PROPOSED HOLIDAY COTTAGES AT DEWHURST FARM

RE: Proposed holiday cottages
 AT: Dewhurst Farm, Longsight Road, Langho

Thank you for your application which we received on Wednesday 1 February 2012. The application has been vetted and unfortunately we'll need some further information before it can be validated:

Proposed South Easterly Facing Elevation 1:100

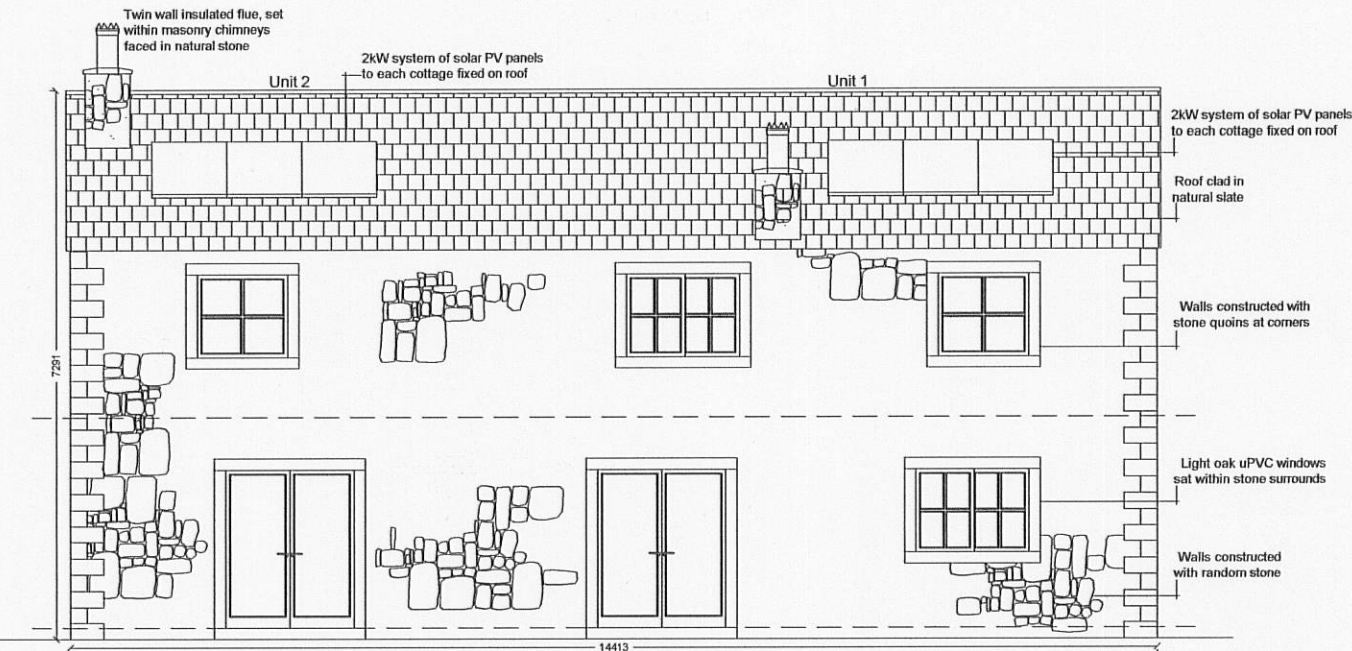
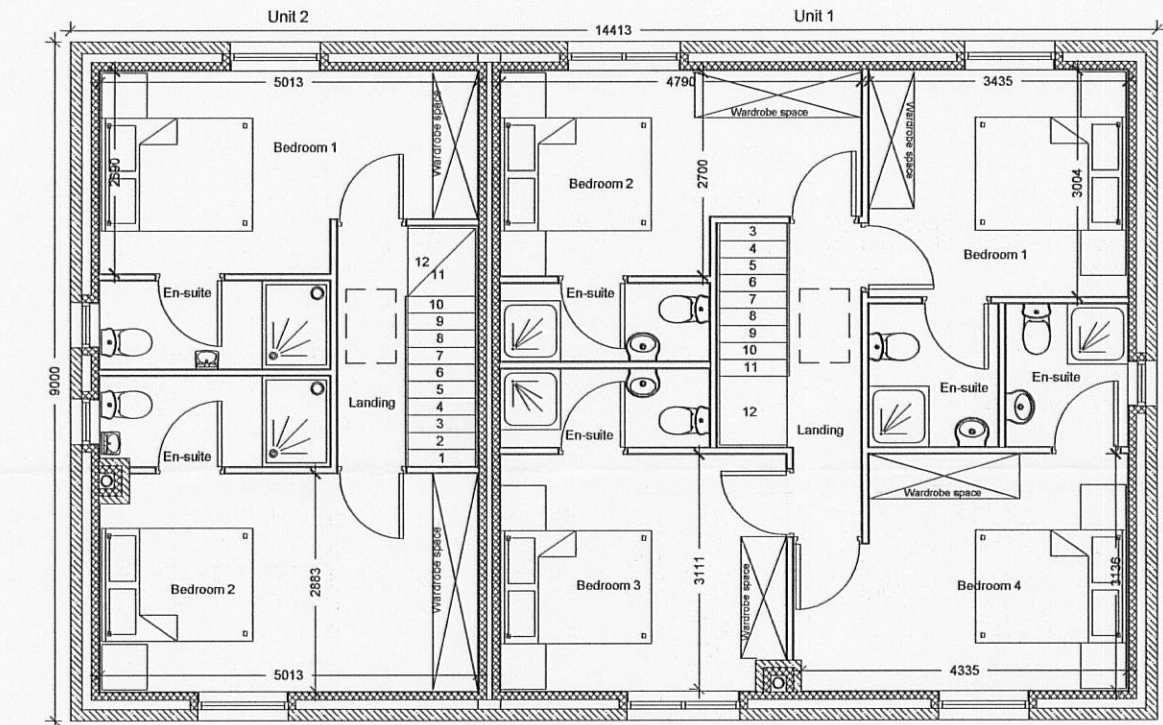
- Finally, the drawings show solar panels on the south-east elevation of the cottages. Please can you provide a technical specification for the panels, i.e. a manufacturer's brochure to show the colour and appearance along with the technical details. The panels should also be annotated with dimensions on the drawings to show their length, width and projection from the roof slope. If you are unable to provide these details at this stage then please be aware that it is likely that a condition will be placed on any consent granted asking for details of the panels to be submitted.

Proposed Site Plan 1:500

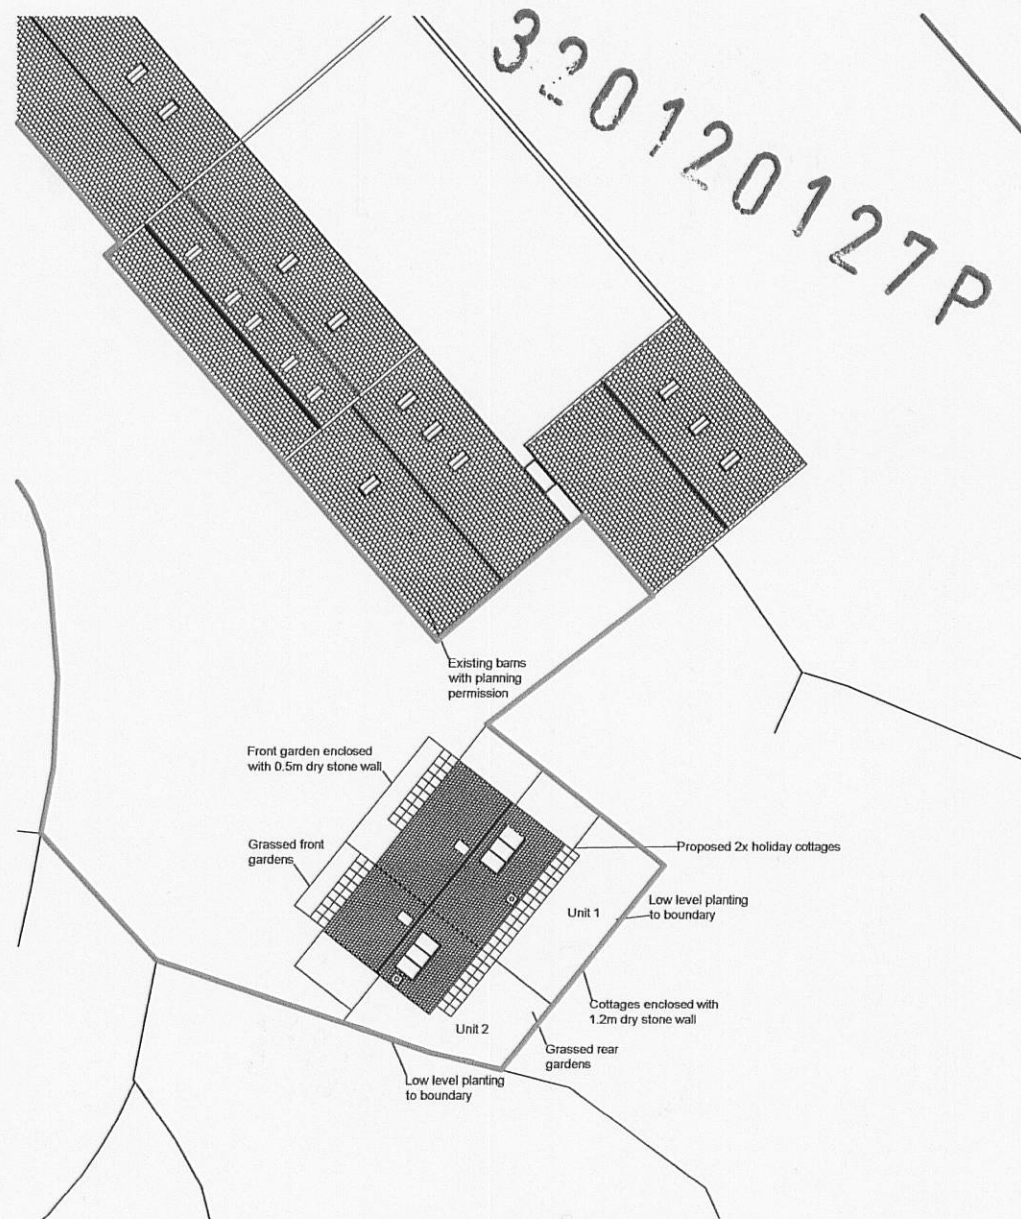
- Please can you provide three copies of a specification for the package treatment plan
- On the 1:500 site plan please can you add dimensions from the proposed cottages to the site boundaries
